**From:** Jennifer Thompson  
**To:** Jean Fraser  
**Date:** 10/19/2015 3:00 PM  
**Subject:** Re: 415 Subdivision Plat for PB - signoffs needed (2015-162)

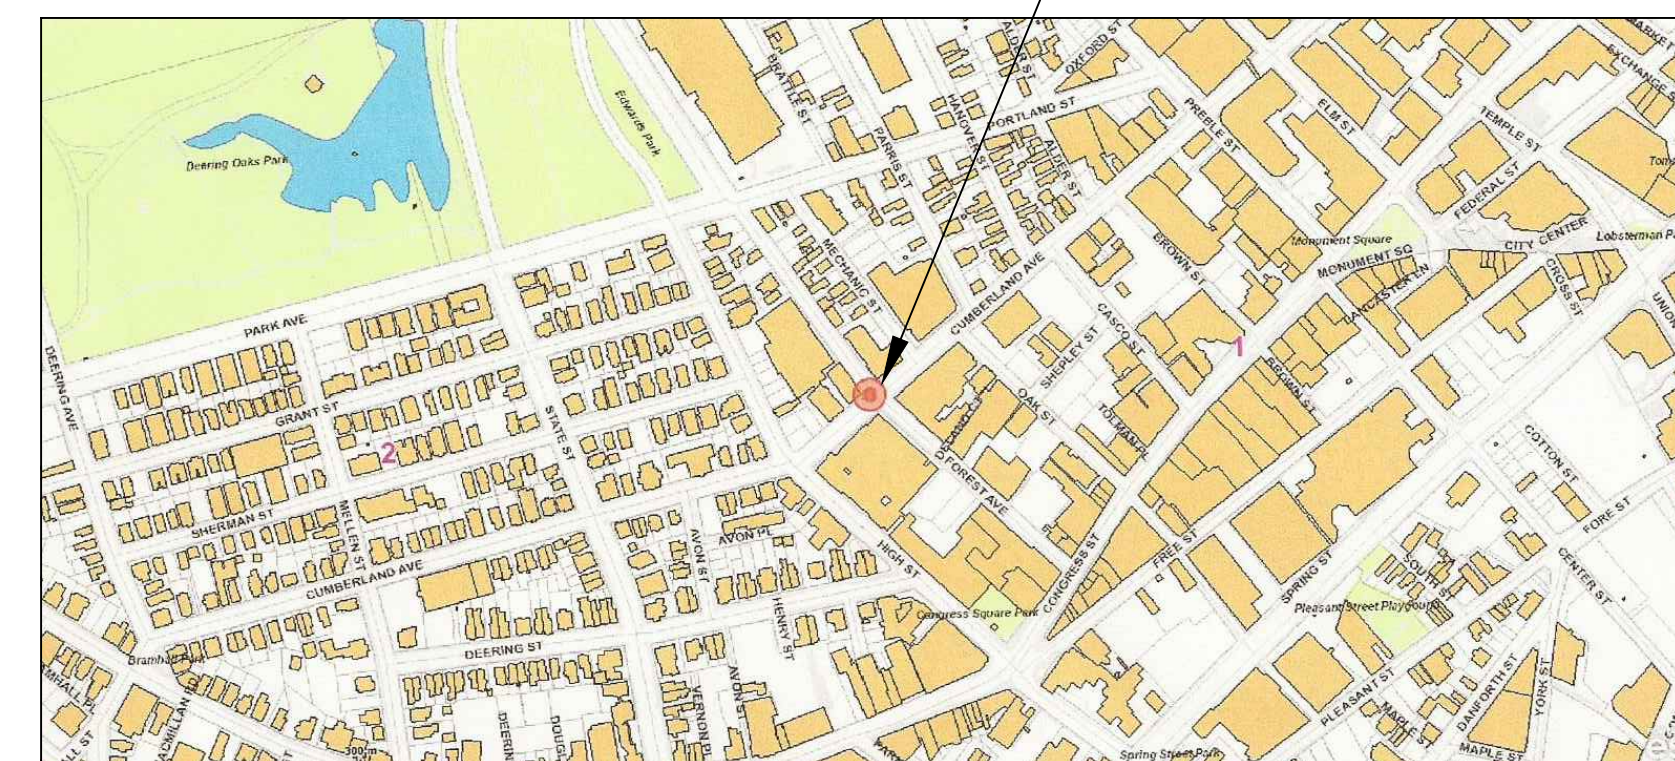
Hi Jean - I think the easements could be better delineated and described. Maybe "YMCA access easement" or something to that effect. Or "easement 1" and "easement 2" with corresponding headings in the notes where they are better described? I'm not sure what Book 3019/page 133 is referring to. Is that a 3rd easement? If so, it should likely also be referenced in the notes. Also, are there parking requirements? I also think the notes could indicate that this is a 10 unit subdivision. If there are not proposed to be any conditions, then I think that's all I've got.
